**KIRKLEES METROPOLITAN COUNCIL  
INVESTMENT & REGENERATION SERVICE**

Reference No:	<b>2025/62/91442/W</b>
Site Address:	34, Moor Lane, Netherthong, Holmfirth, HD9 3UW
Description:	Demolition of existing garage and erection of single storey front and two storey side extensions and associated alterations
Recommending Officer:	Joshua Merriman

## HOUSEHOLDER DELEGATED REPORT

<b>Application Number</b>	2025/91442
<b>Location</b>	34, Moor Lane, Netherthong, Holmfirth, HD9 3UW.
<b>Proposal</b>	Demolition of existing garage and erection of single storey front and two storey side extensions and associated alterations.
<b>Publicity end date</b>	17/07/2025
<b>Number of representations received</b>	1.
<b>Kirklees Local Plan Allocation/Designation</b>	The application site is allocated within a bat alert layer and a twice buffer.
<b>Extension to Time (EoT)</b>	No
<b>Recommendation</b>	Conditional Full Permission

DRAWING TITLE
PROPOSED FLOOR PLANS

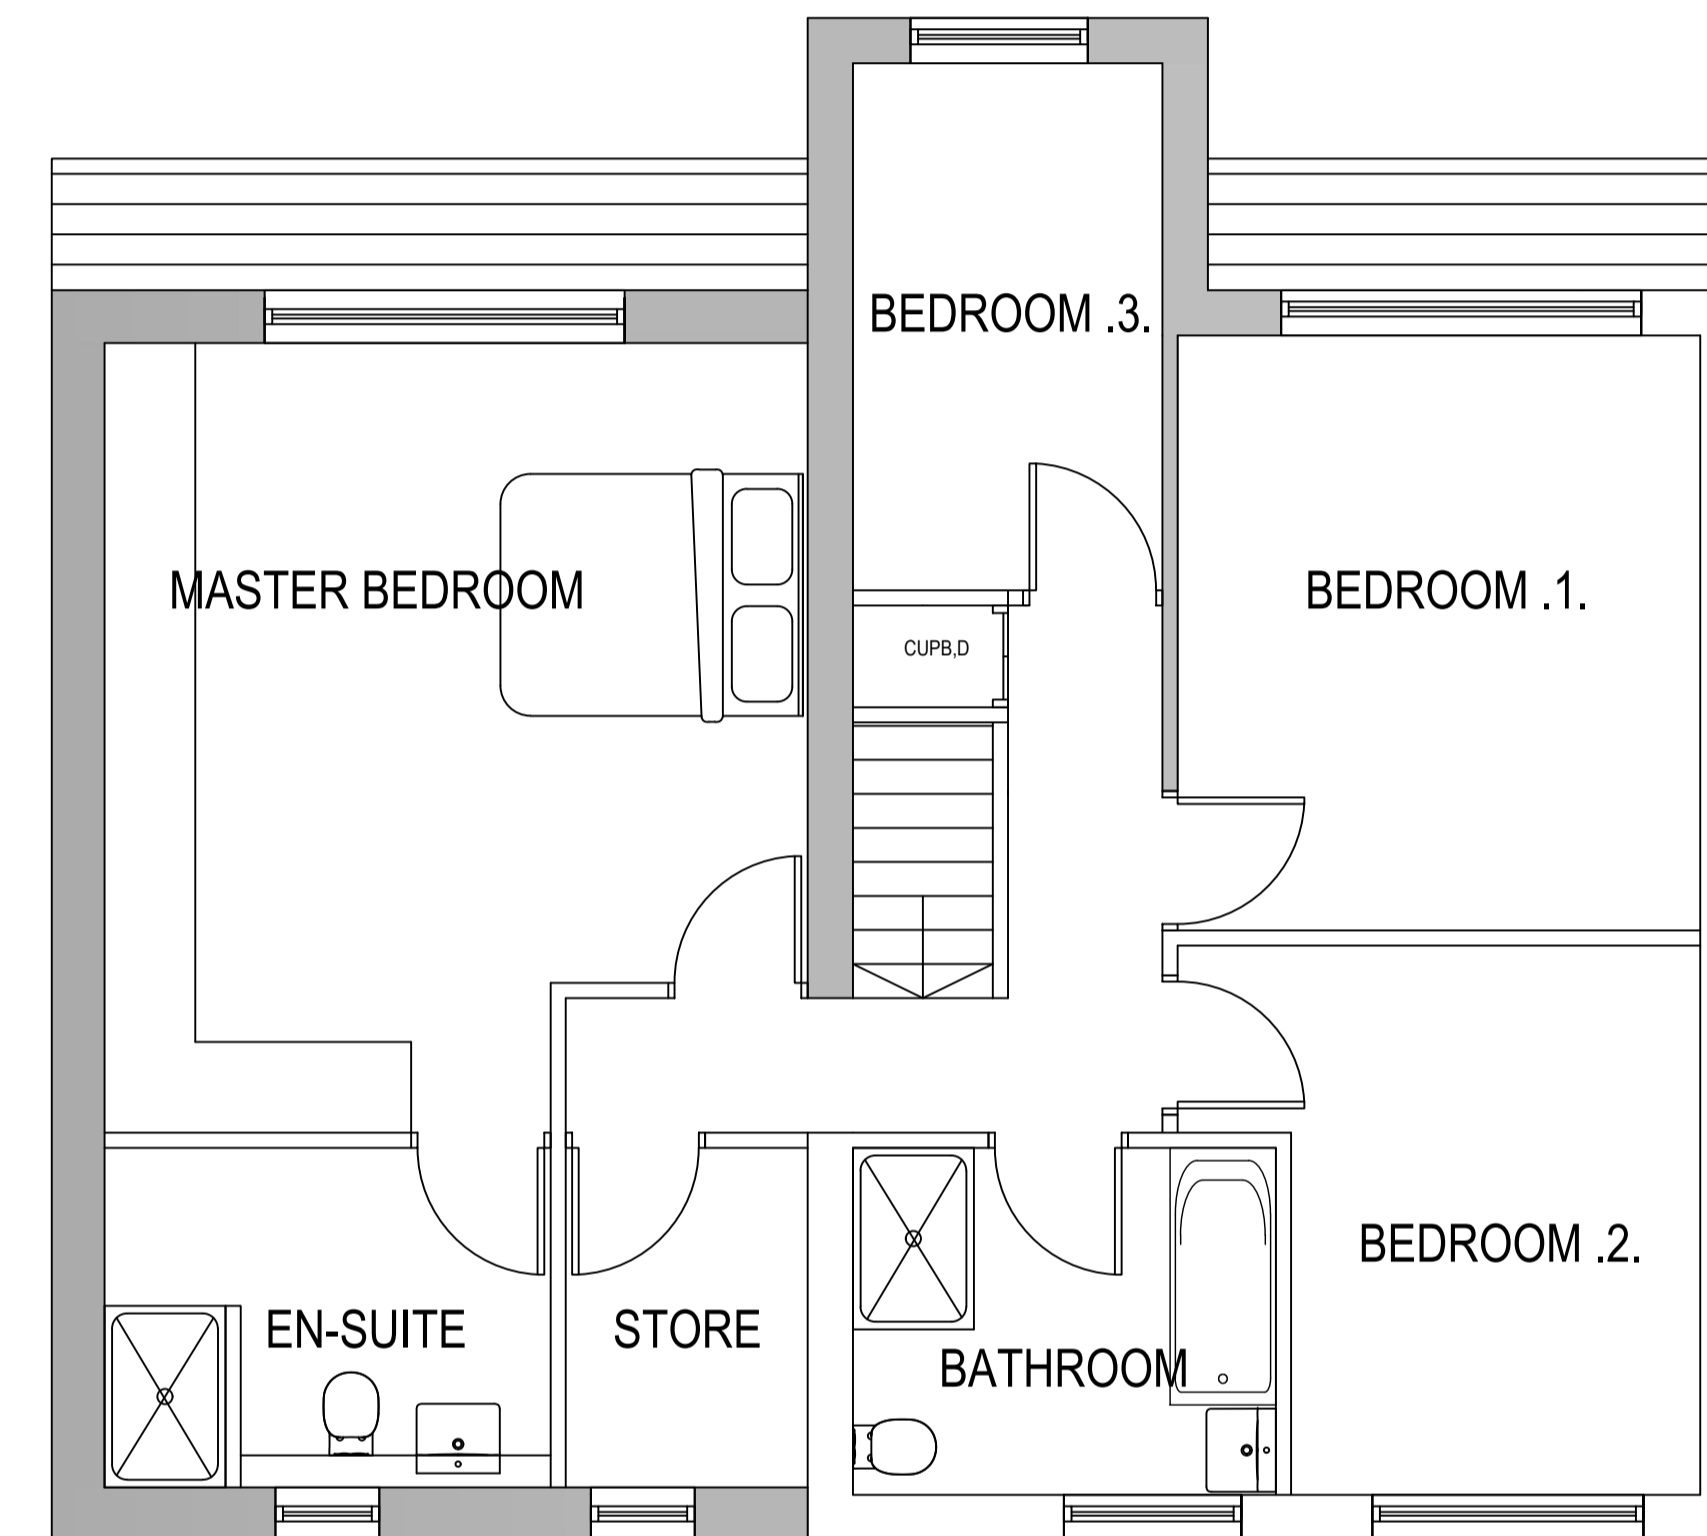
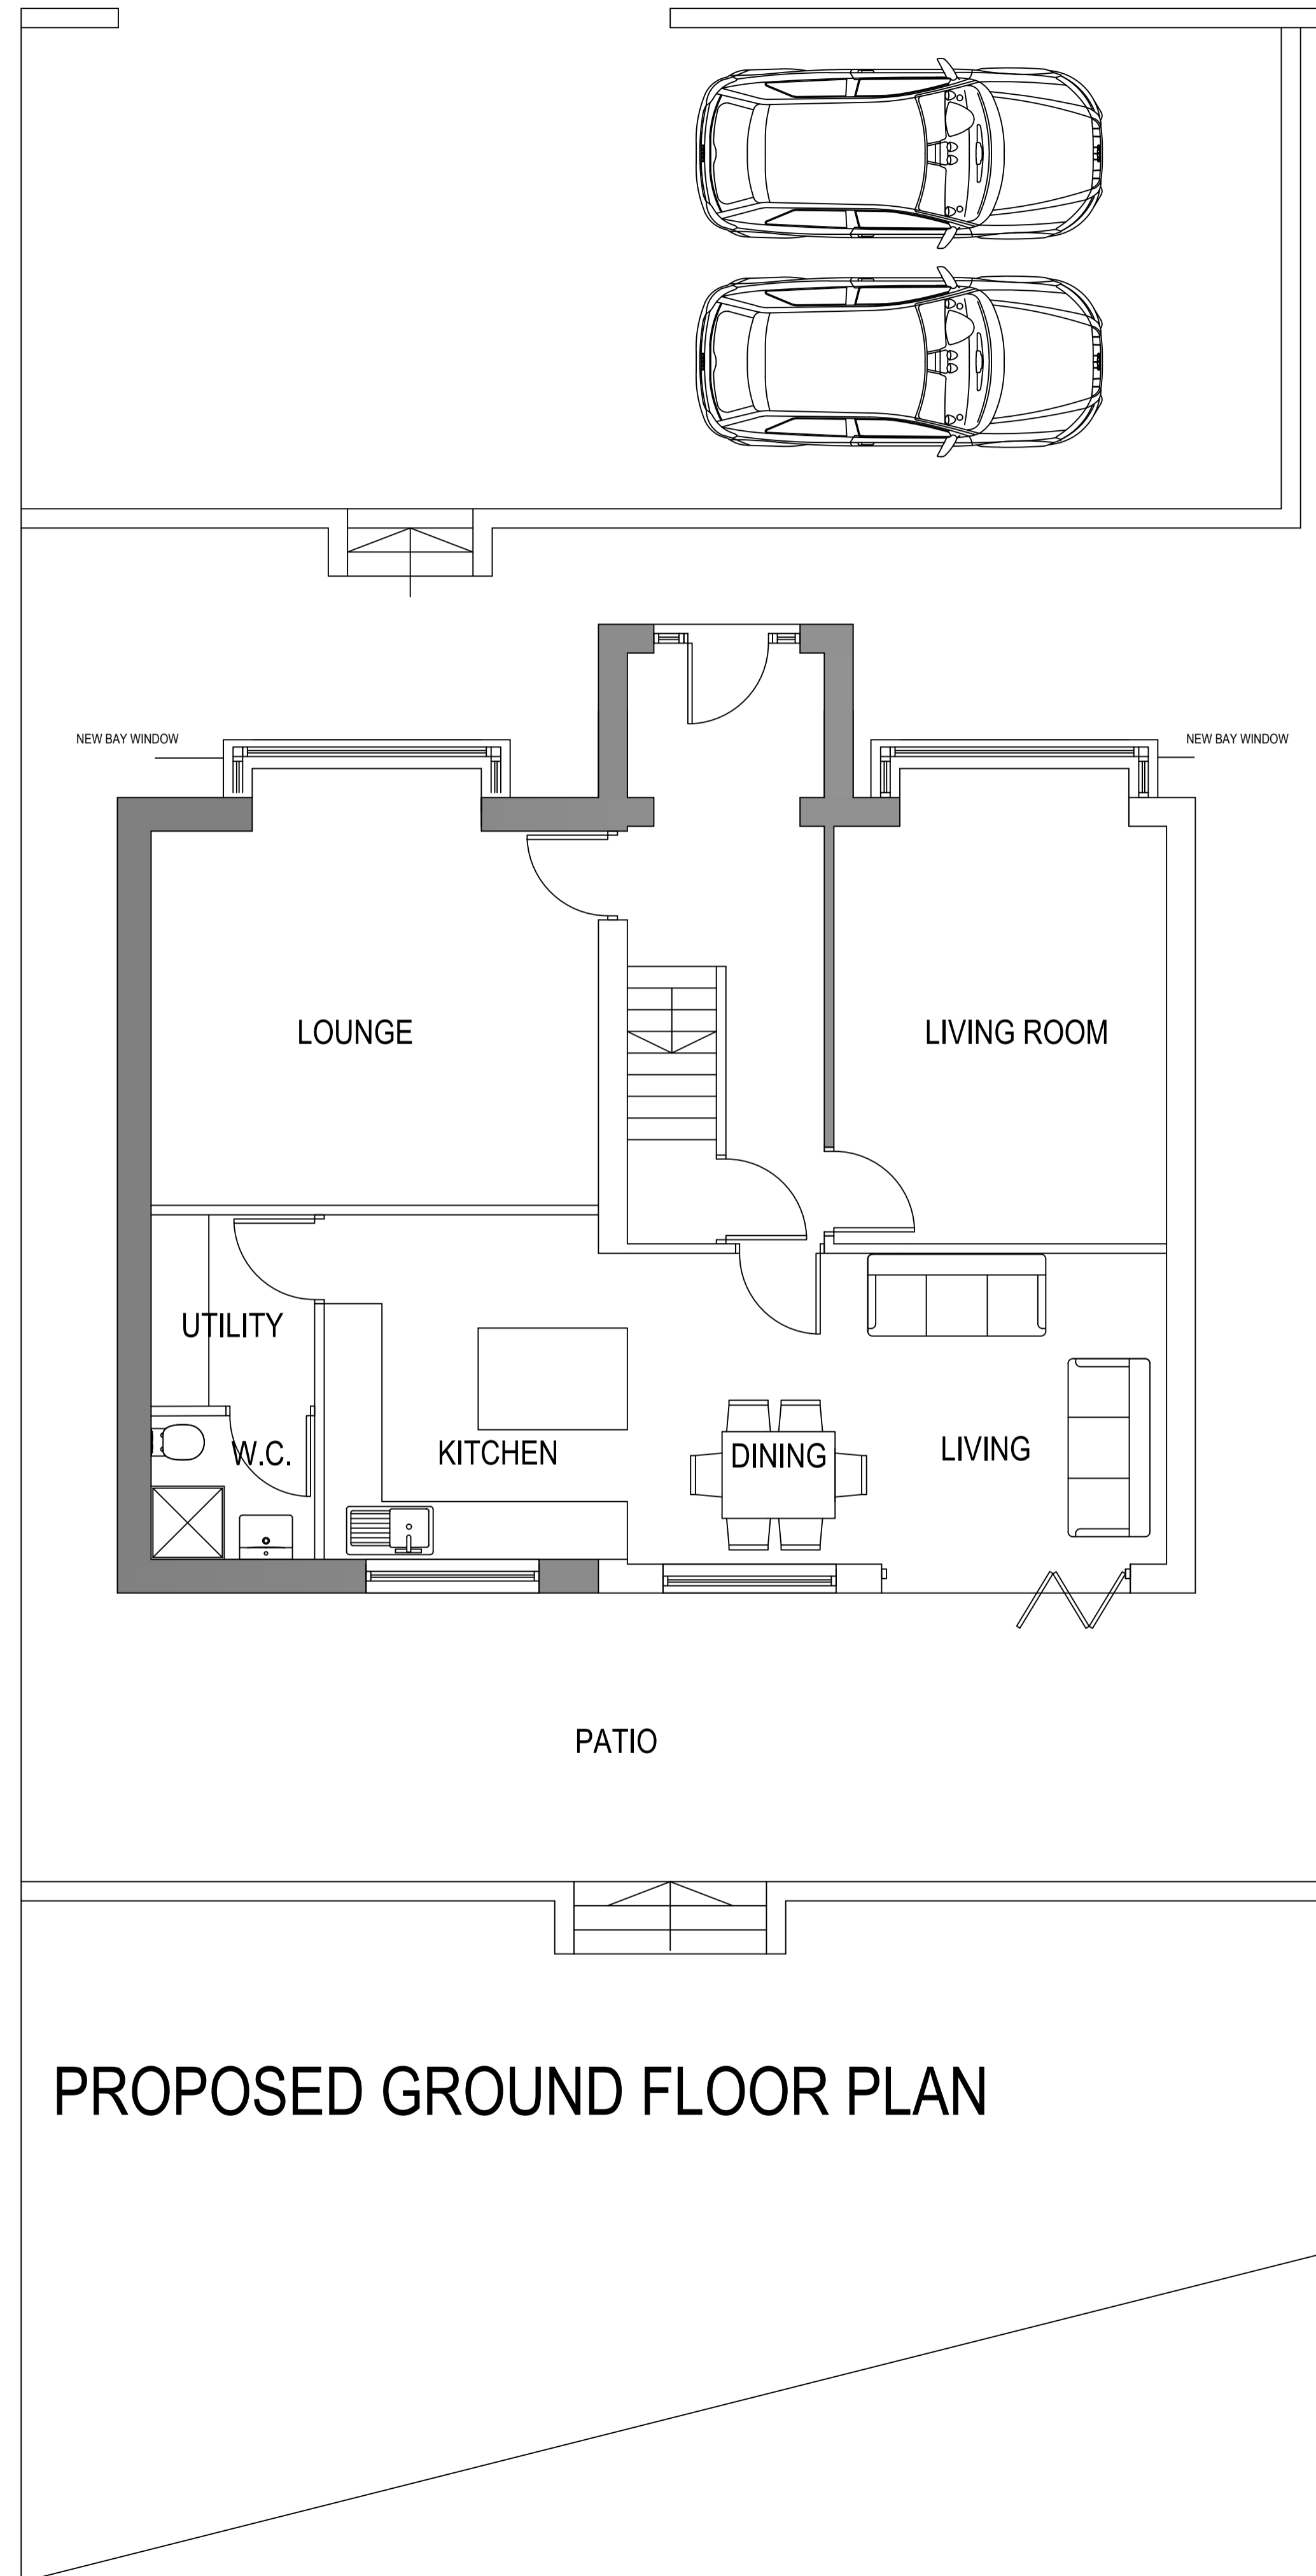
The proposed front extension will project 2.04m from the front elevation of the original house, with a maximum height of 3.49m, eaves height of 2.23m, and a width of 2.94m.

The proposed two storey side extension will project approximately 6.02m from the side elevation of the existing building, with a maximum height of 7.84m, eaves height of 5.28m, and a depth of 8.3m – All matching the existing building.
